HIGHWAY REPORT ON PROPOSALS FOR DEVELOPMENT

DISTRICT:	Bassetlaw	Date received	09/10/2023
OFFICER:	Kirsty Harte		
PROPOSAL:	Change of Use of former Community Centre Building into Self-Contained Dwelling	D.C. No.	B/23/01190/COU
LOCATION:	Community Centre 35 Northumberland Avenue Costhorpe Worksop Nottinghamshire S81 9JP		
APPLICANT:	Mr M Dane

## Proposed Block Plan Scale 1:500 At A4 Sheet

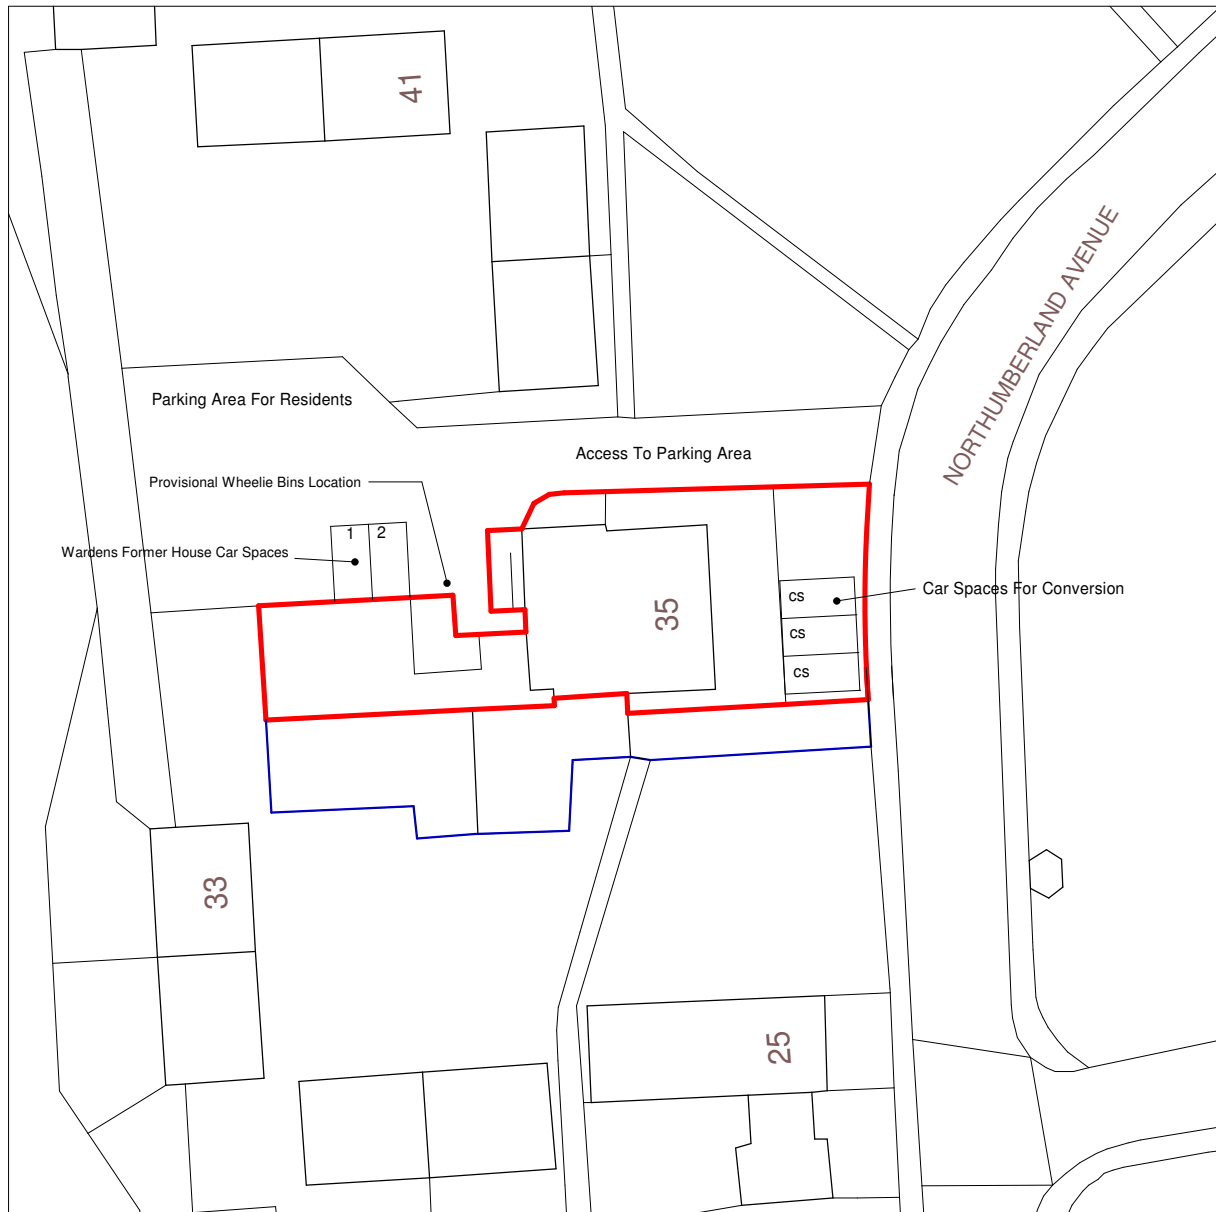
Whilst there are no objections to the principle of the change of use, the Highway Authority requests that off-street car parking provision for both the proposed community centre conversion and the former warden's house (outlined in blue) is shown on the proposed block plan at a suggested rate of 2 car parking spaces per dwelling. The proposed parking spaces must not prevent pedestrian access to either property.
